**Re: Gracia Cadillac  
1220 S. Renaissance NE  
Traffic Circulation Layout  
Engineer's Stamp 02-24-2021 (F16-D003I)**

Based upon the information provided in your submittal received 03-23-2021, the above referenced plan cannot be approved for Building Permit until the following comments are addressed:

Valley Gutter Detail

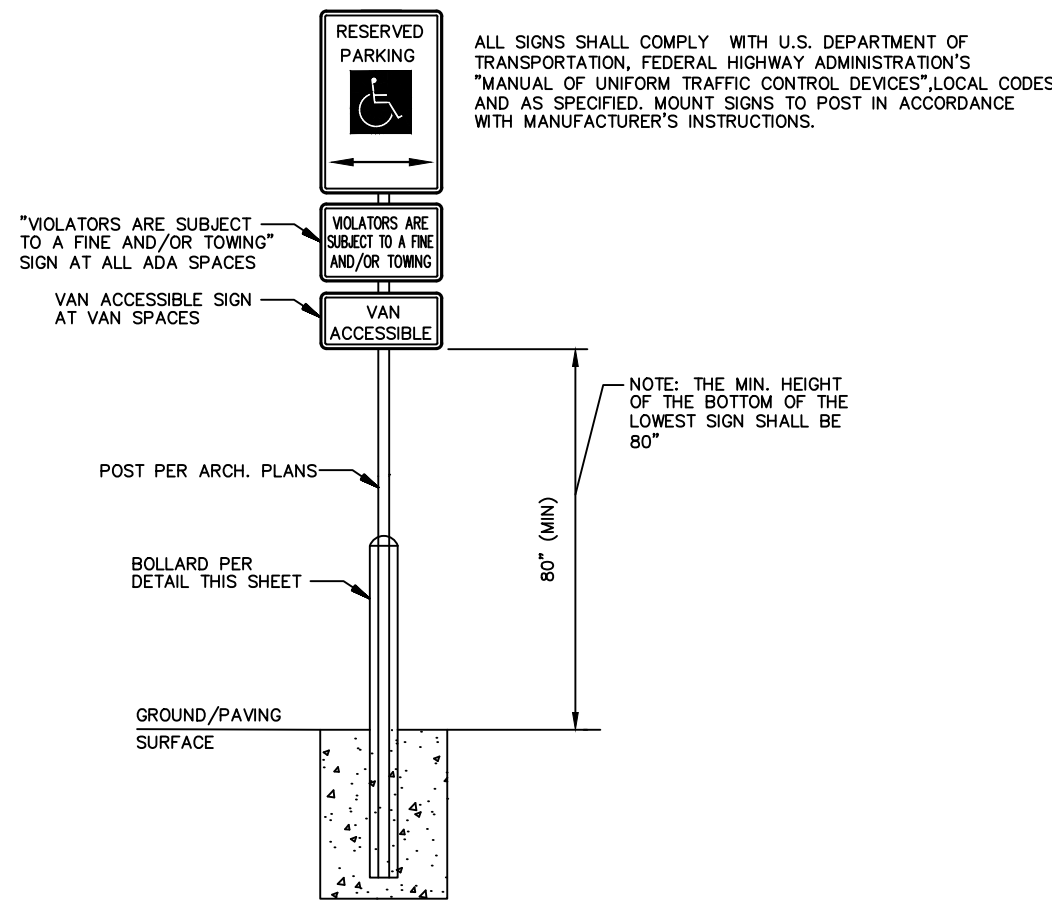
2. **Key Note 23: It appears that you are attaching a partial of the valley gutter and not the whole segment. So, if this is the case then you will need to dowel into existing concrete. Review COA std dwg 2420 for valley gutter and see if this type of doweling will function for this condition. Why not replace the whole segment of the valley because it appears that you are only replacing a partial of the vally gutter sides.**
